From: Kelly Male (MHA) [REDACTED]
Sent: 19 October 2021 10:58
To: Paul Cann <Paul.Cann@arun.gov.uk>
Cc: Anita Gardner <Anita.Gardner@arun.gov.uk>
Subject: RE: AB/112/21/DOC (Canada Road)
Importance: High

Please find attached addition information following your comments with regards to conditions 4 & 5 of the Canada Road, Discharge of Conditions application.

Engineers comments on surface water drainage (Conditions 4 & 5);

HIGHWAY RETAINING WALL  
HOLLOW BLOCK WALL

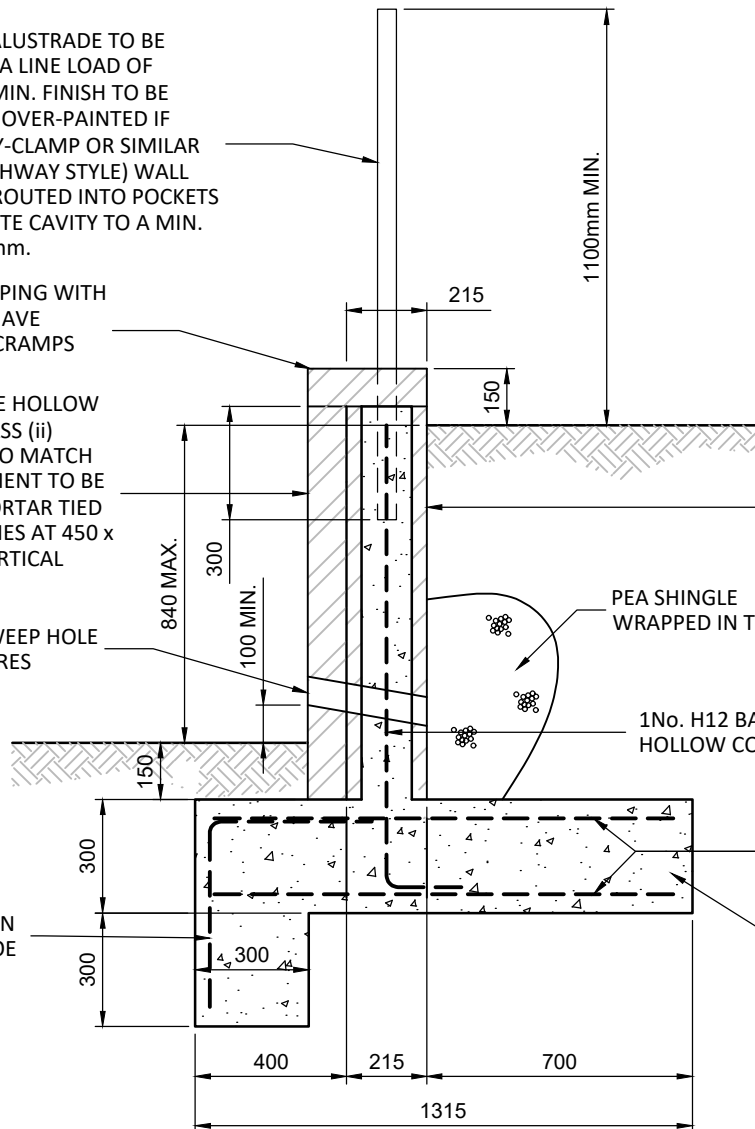
3. Highway retaining walls noted to include weepholes/granular backfill – please update note on plan. Annotation update to coordinate with the WSCC approved data (also enclosed).

TYPICAL CATCHPIT DETAIL (1200Ø)
(Scale 1:20)

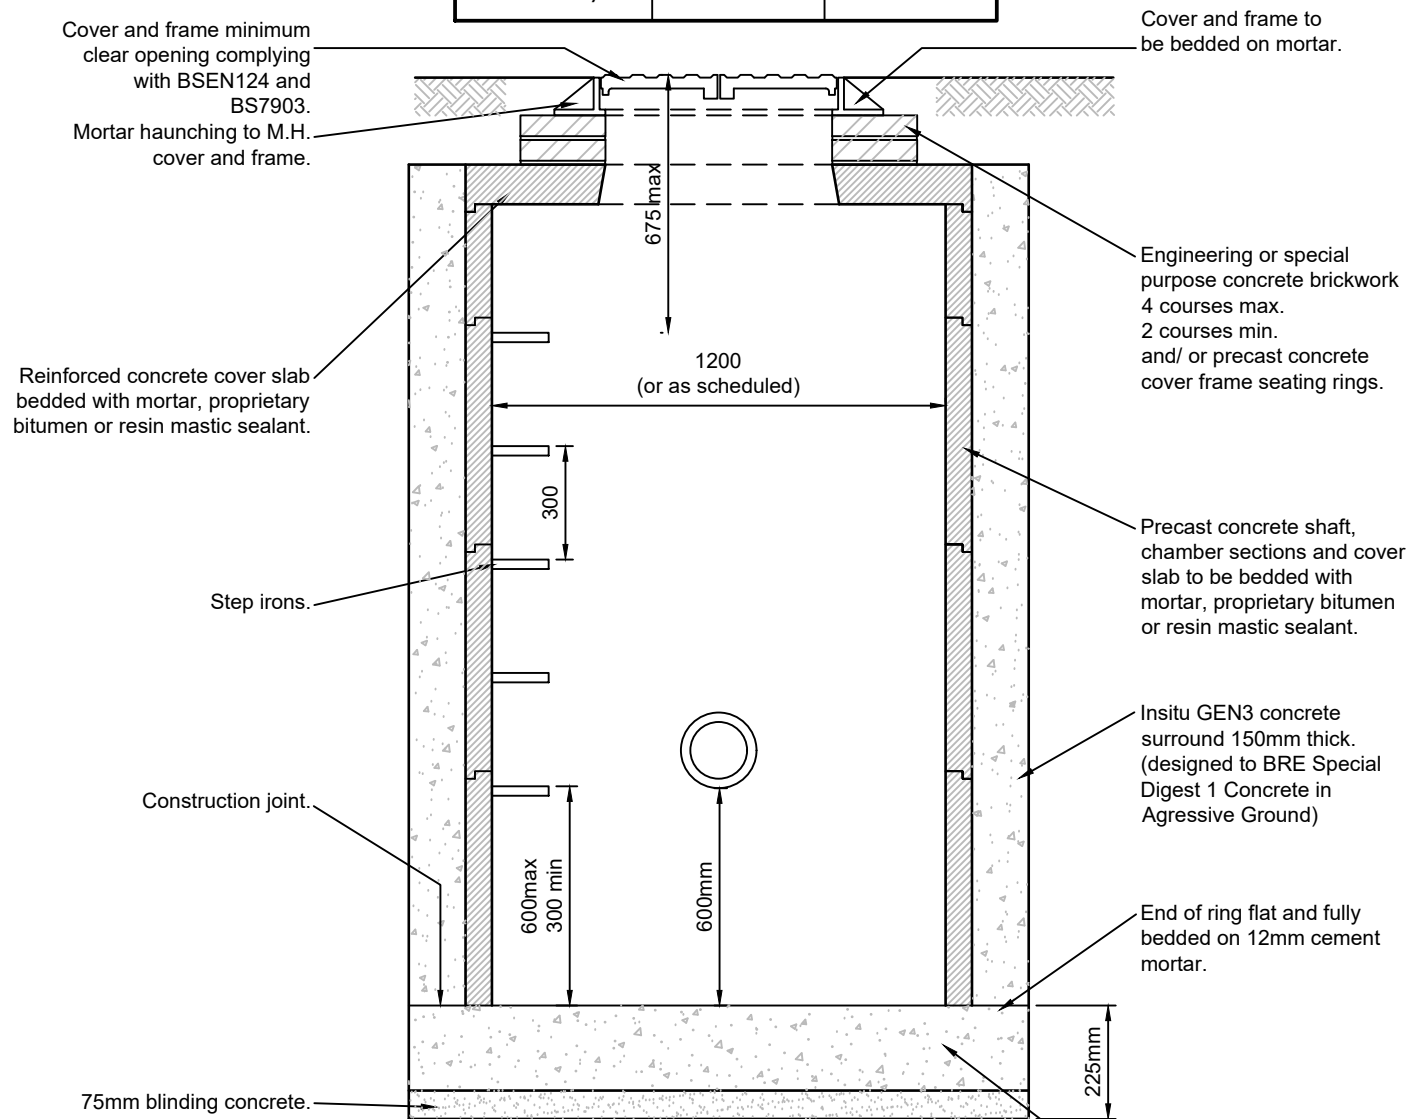
b) Catchpits – specify ductile iron covers & frames of suitable load grading. Noted and updated.

SECTION A-A

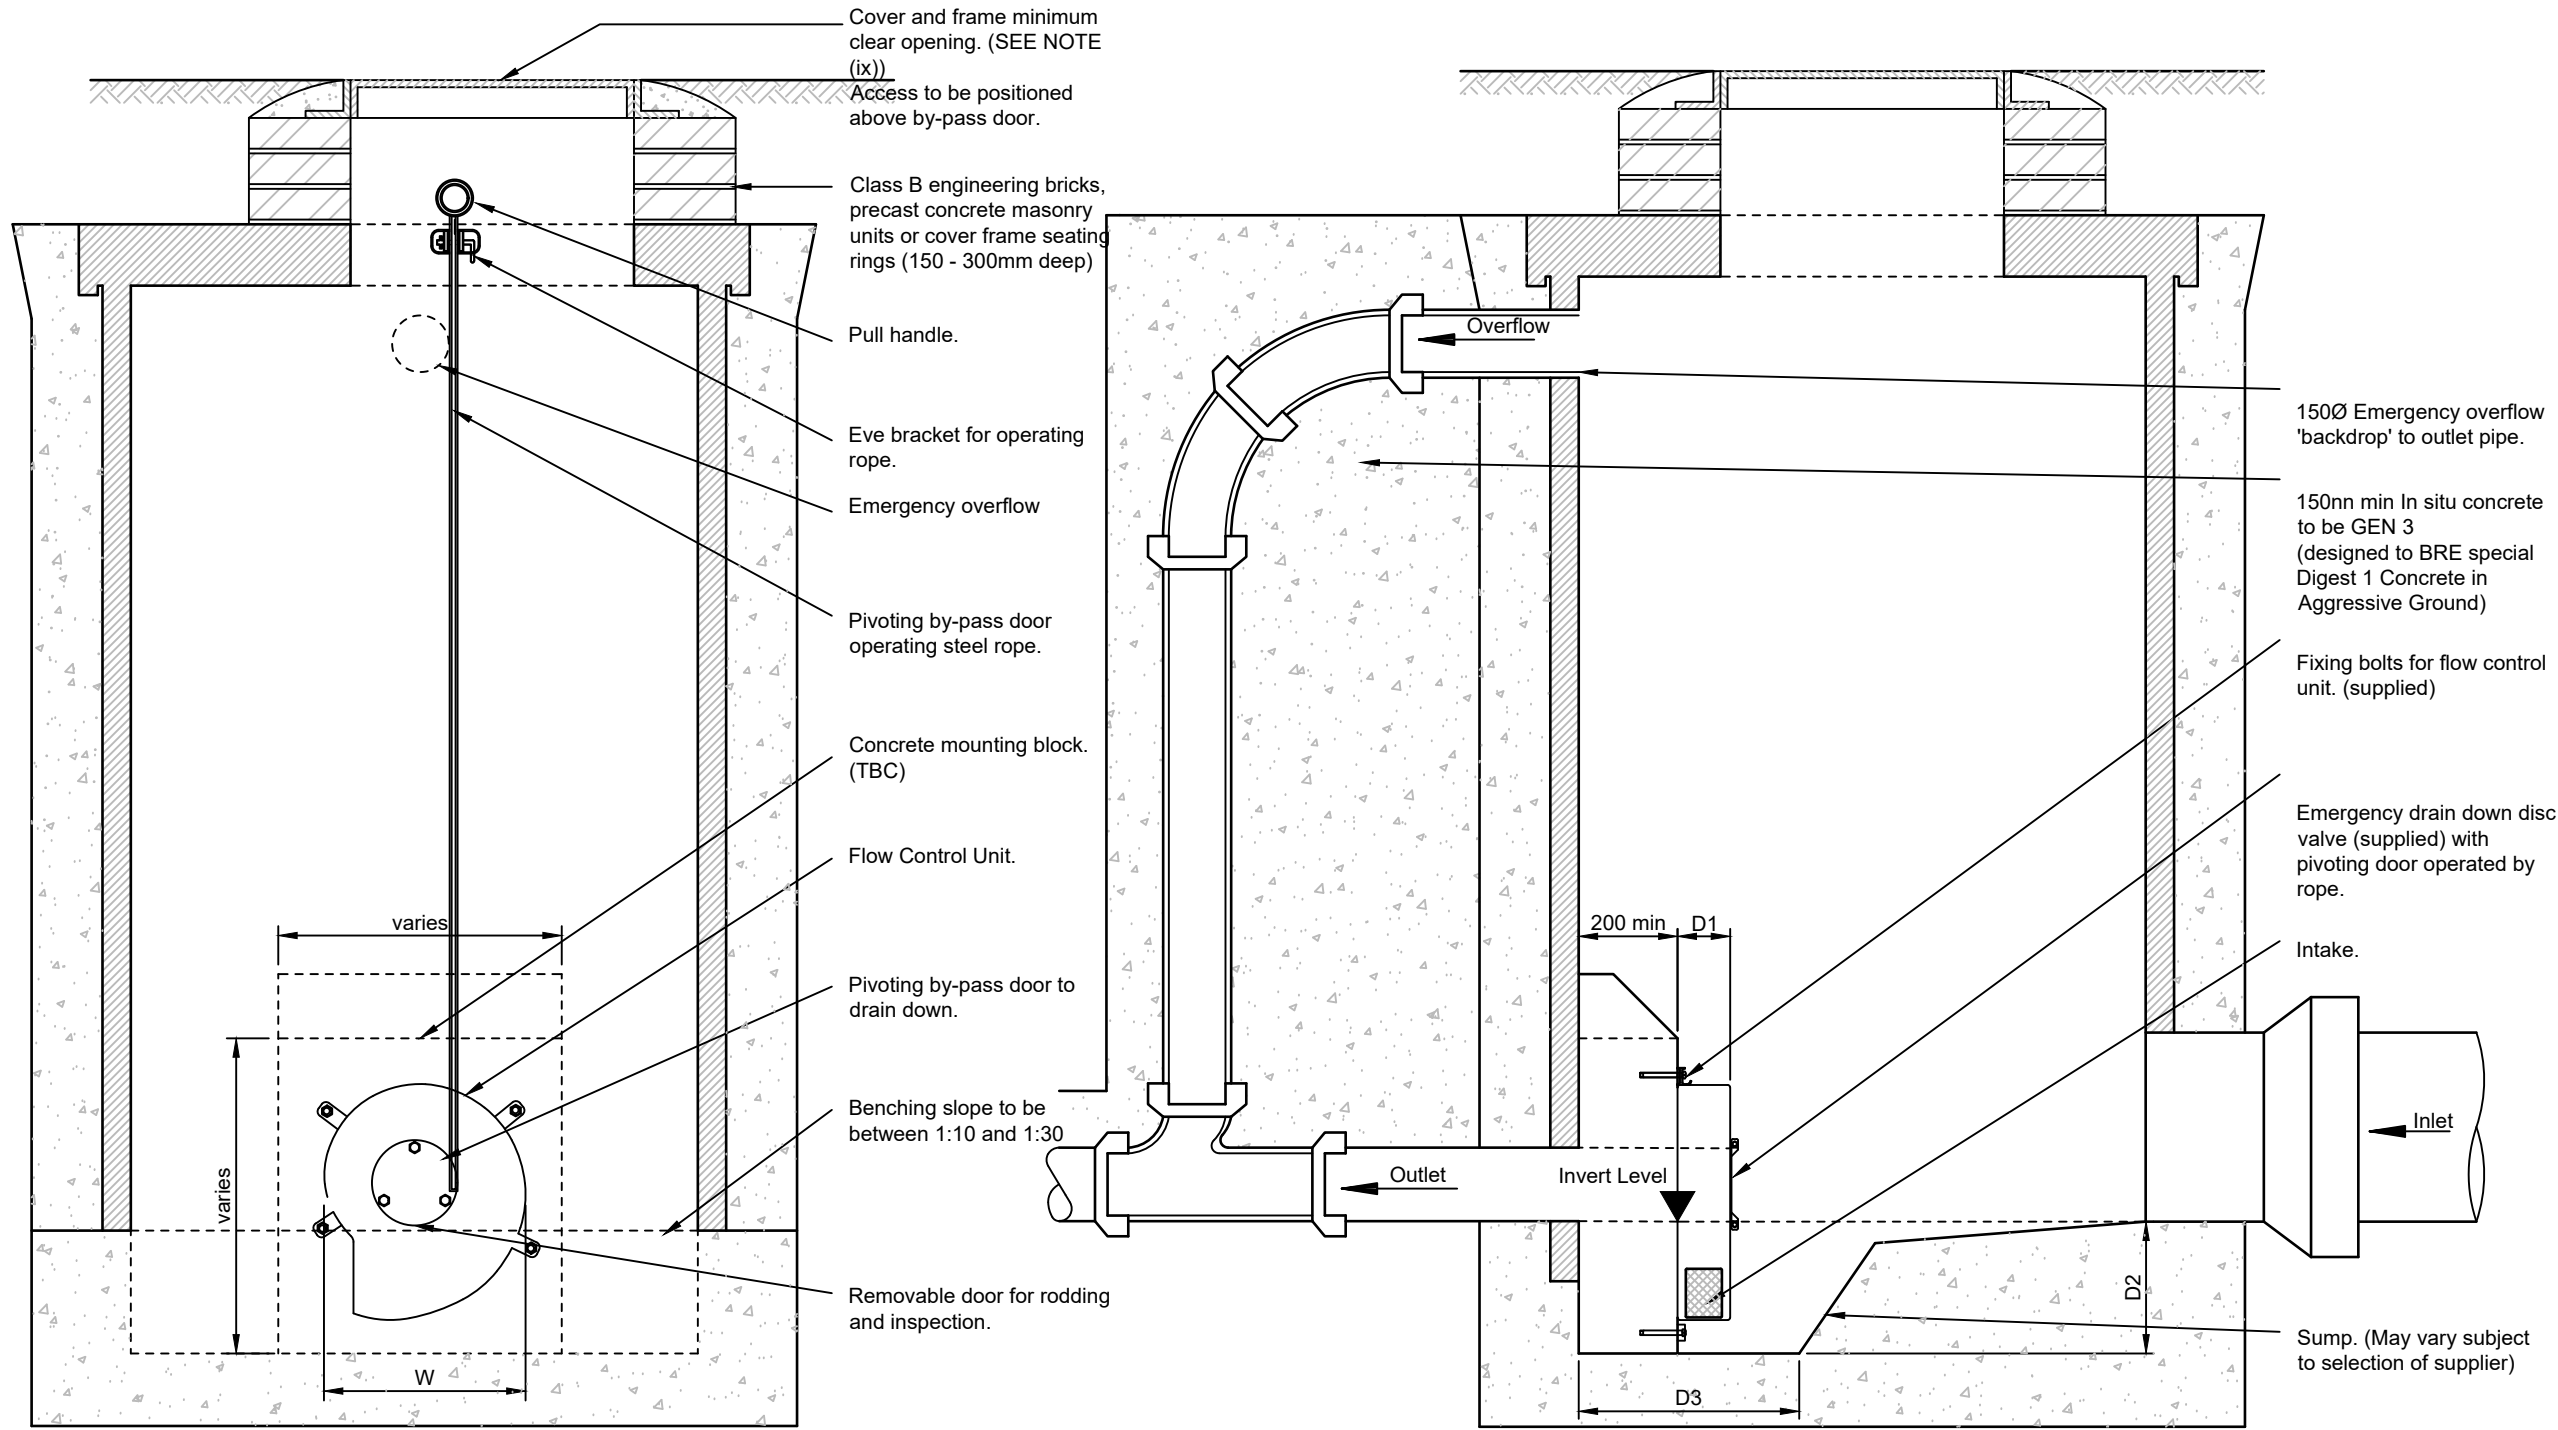
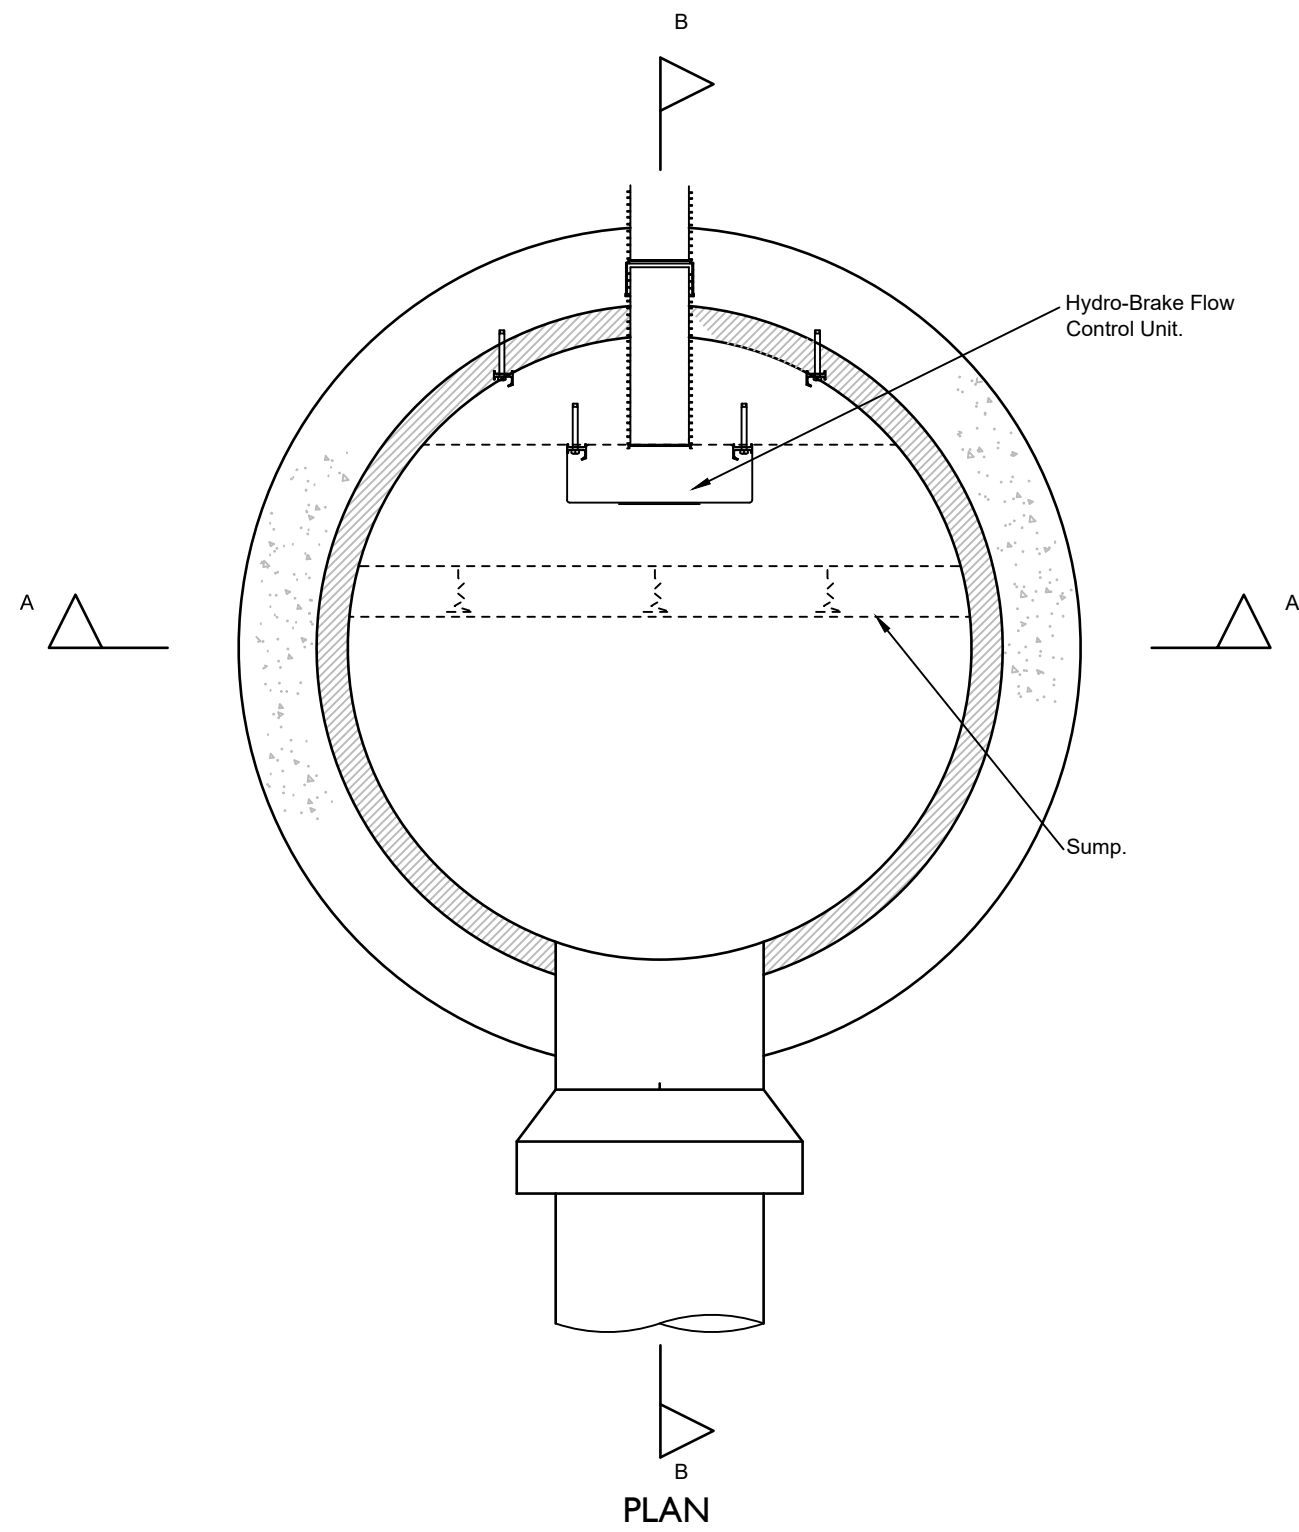
c) Provide control chamber detail. Noted and updated.
